**Application** H16-0923-25  
**Location** The Sessions House Sheep Market Spalding PE11 1BB  
**Proposal** Erection of a freestanding, fully reversible outdoor servery unit to function as a coffee/bar area within the rear courtyard

**Name** Spalding & District Civic Society  
**Address** Spalding

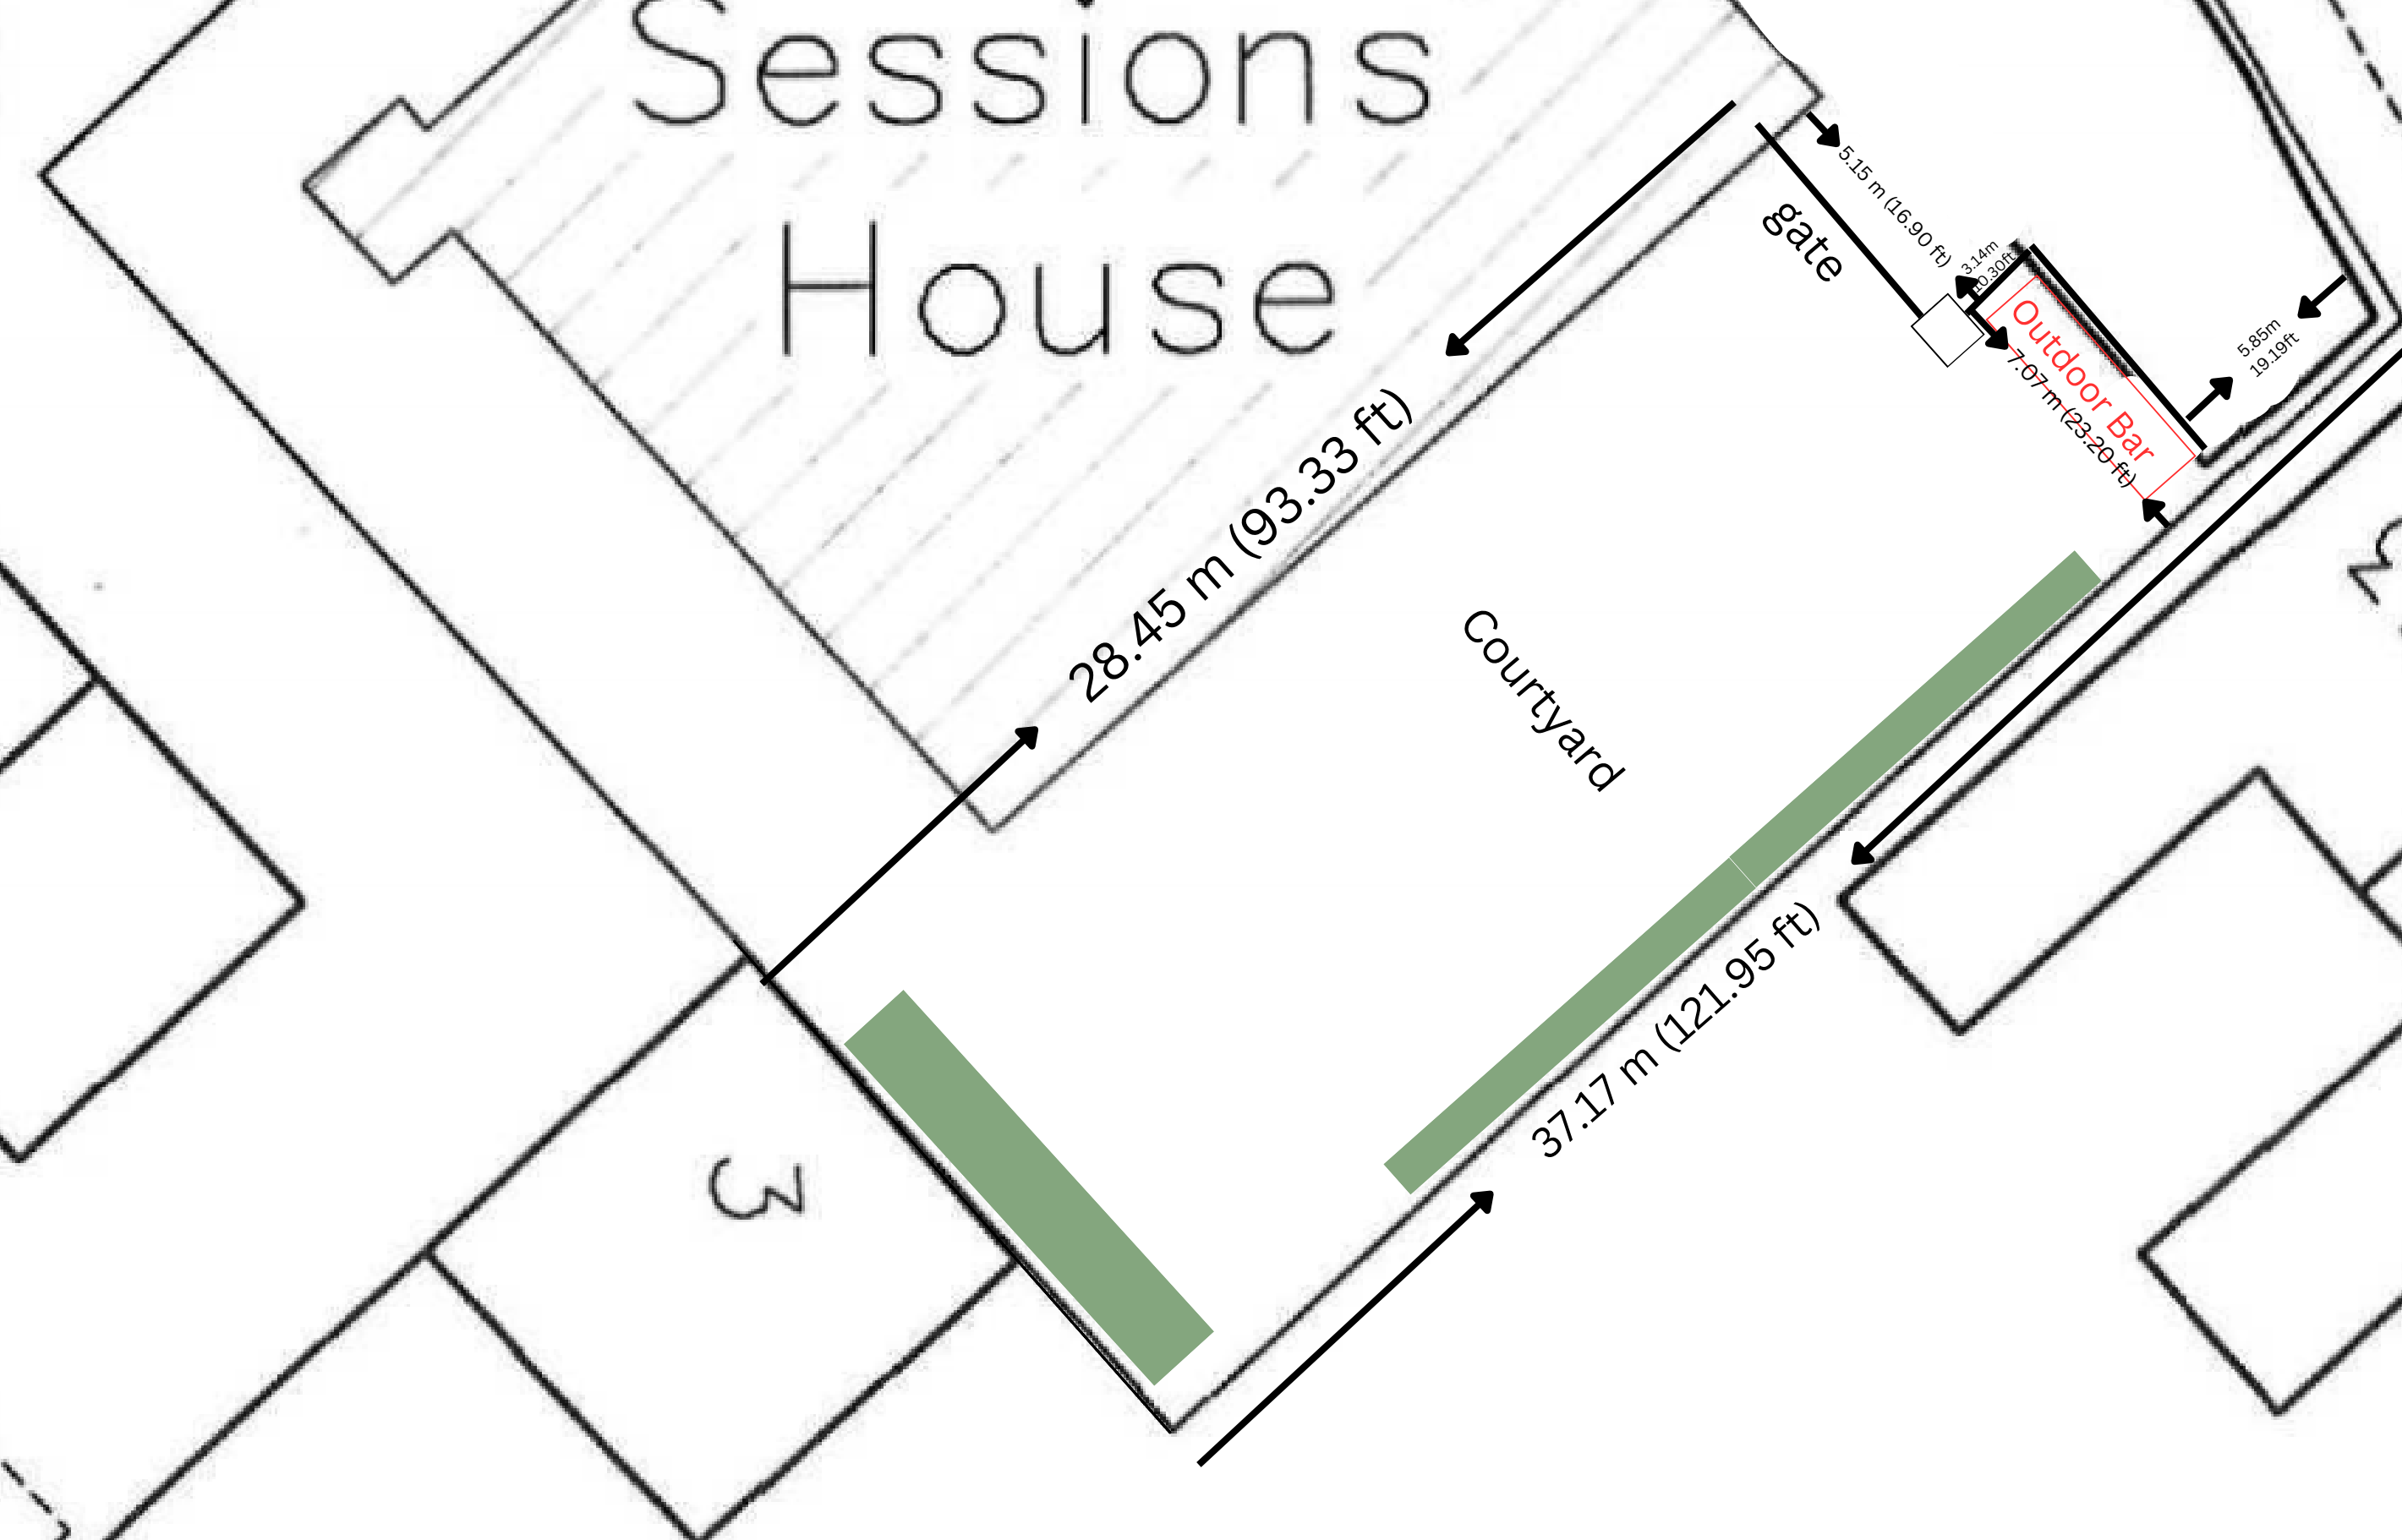
There is not enough information in the way of details of the building or materials to be used to consider this application properly. The facility is up and running, so the application should be considered retrospective. The materials used conflict with those stated in the application.
